Project# 1010038 - 15DRB-70212 MINOR - PRELIMINARY/ FINAL PLAT APPROVAL

NAME: THE NEW HOLIDAY PARK SUBDIVISION

**CITY OF ALBUQUERQUE
PLANNING DEPARTMENT
June 3, 2015
DRB Comments**

RE: Tract C, The New Holiday Park Subdivision

**SUBDIVISION PLAT OF
TRACTS C-1, C-2 AND C-3
THE NEW HOLIDAY PARK**

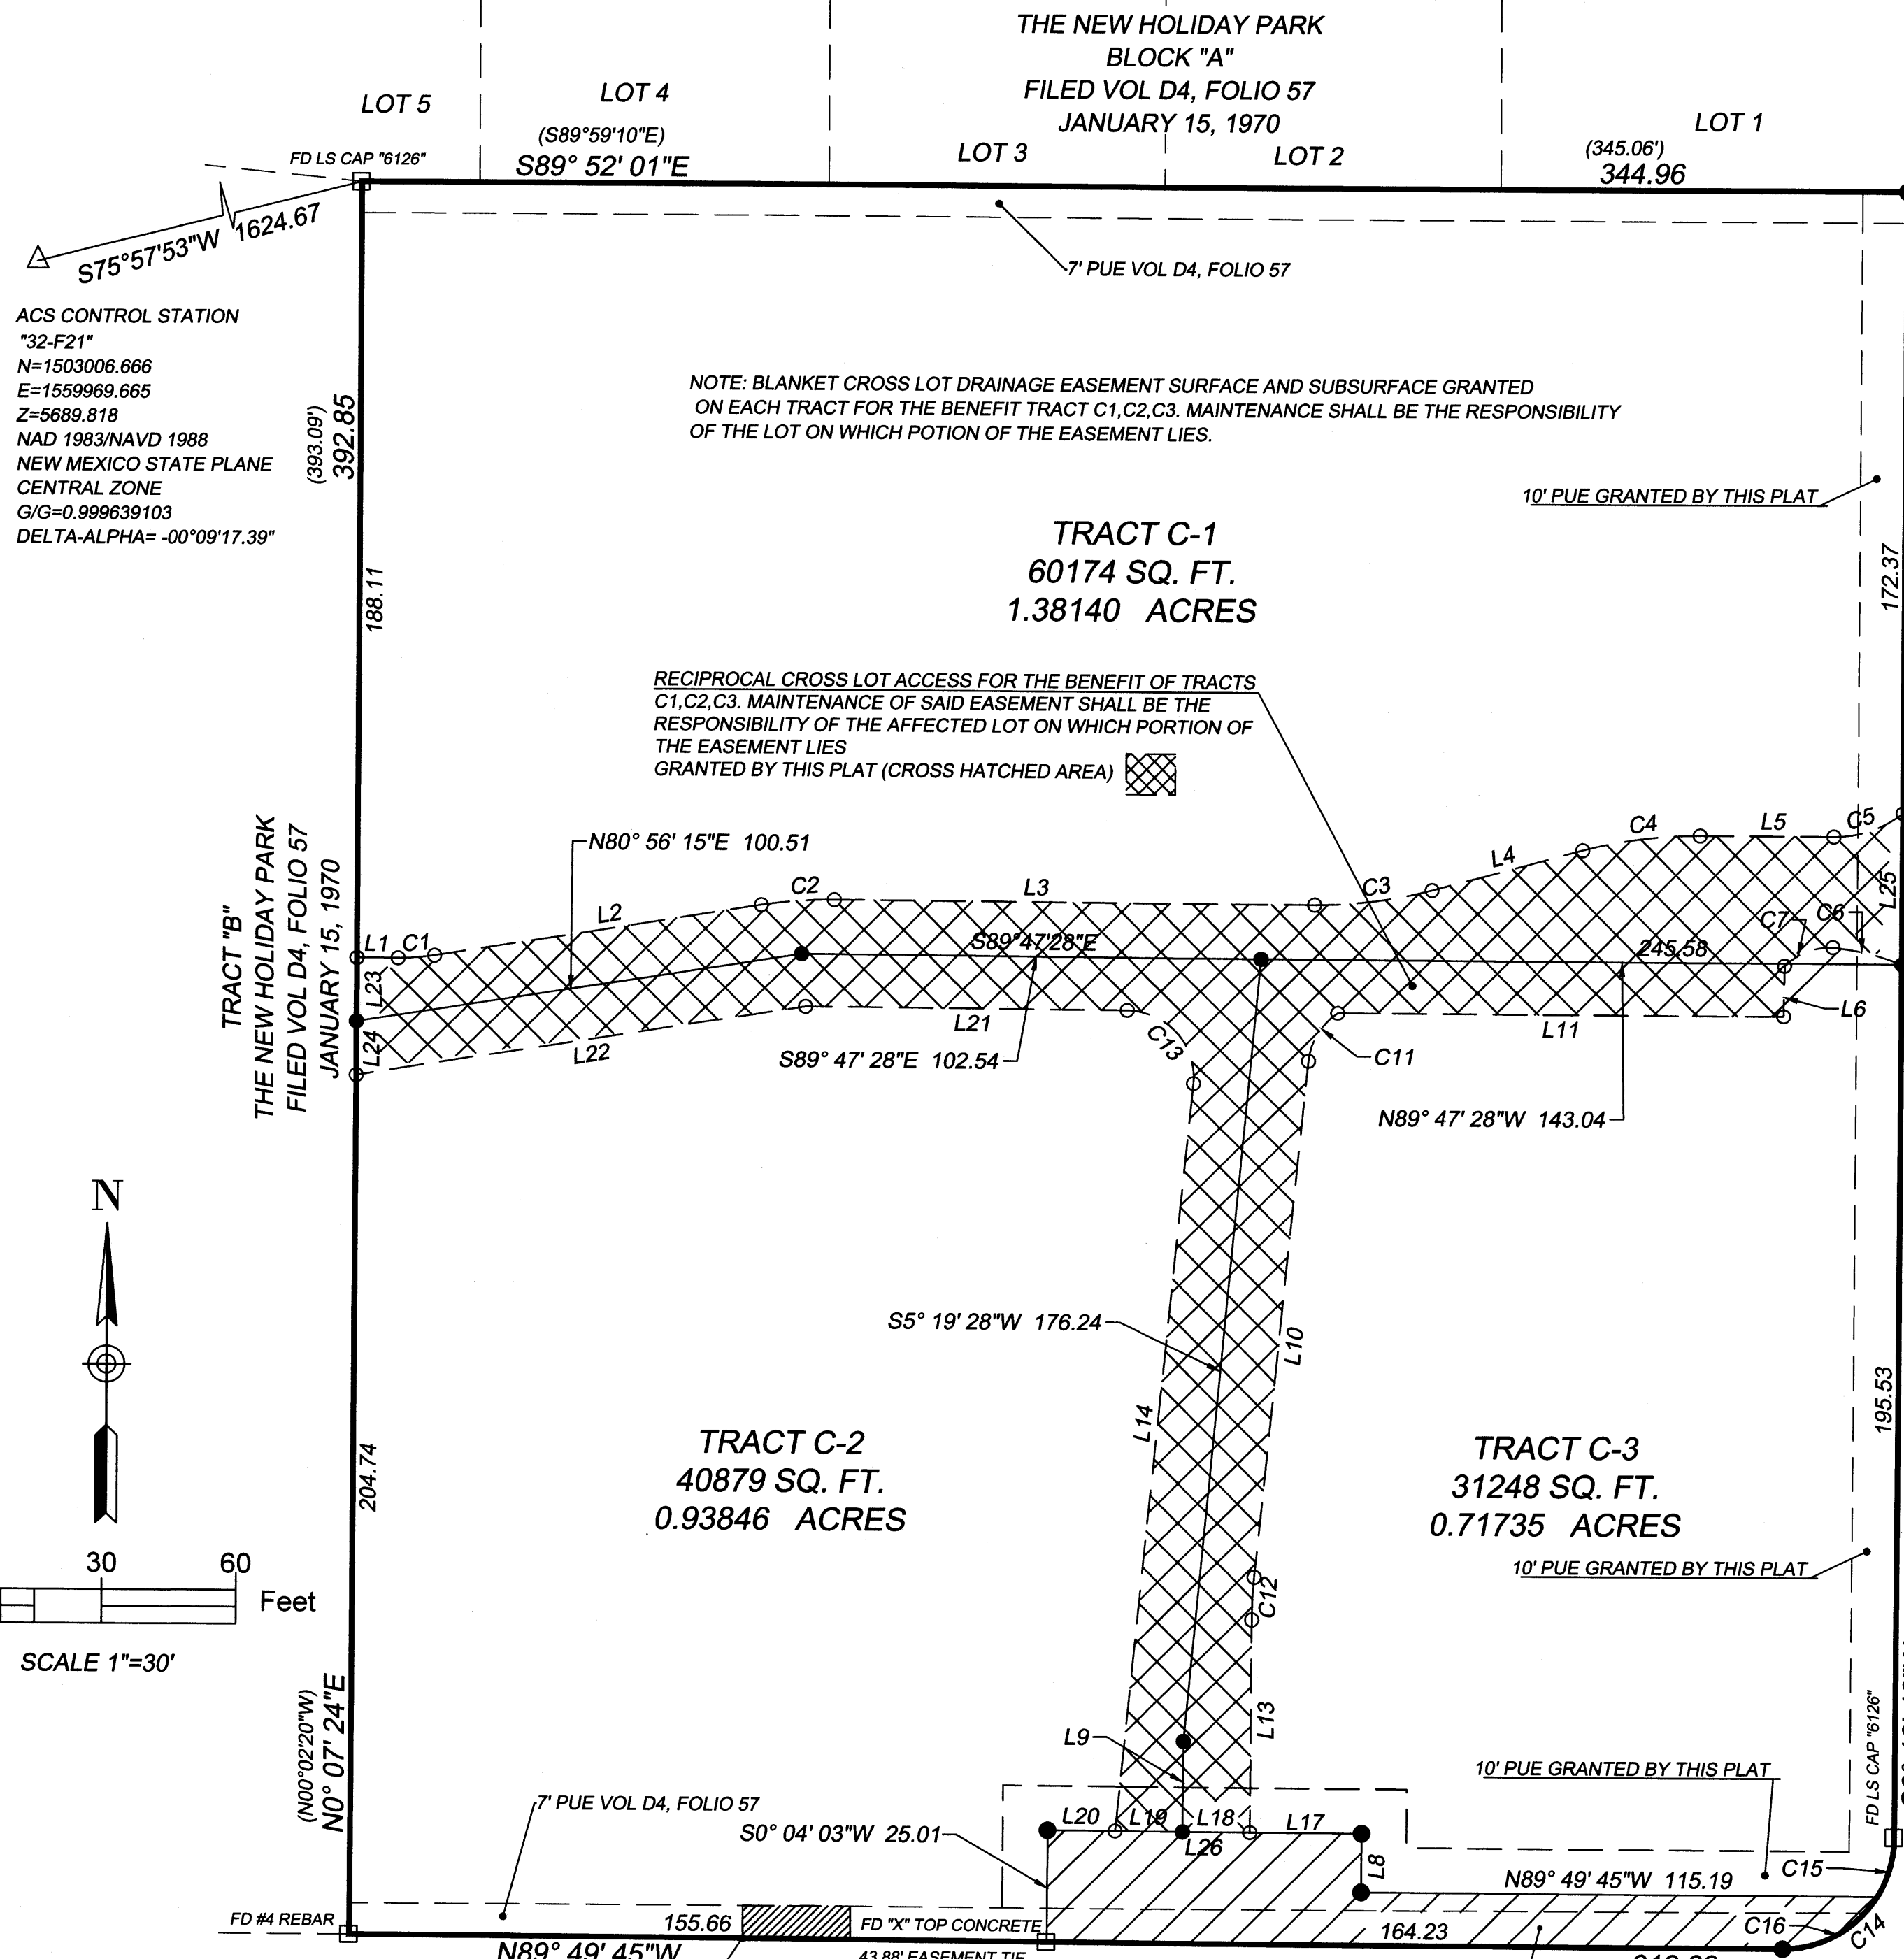
Vacation of a Public Utility Easement requires a specific application to DRB and an advertised public hearing.

Maintenance of the Reciprocal Easement and Blanket Drainage Easement needs to be specific – “Responsibility of the Affected Lot” is too ambiguous.
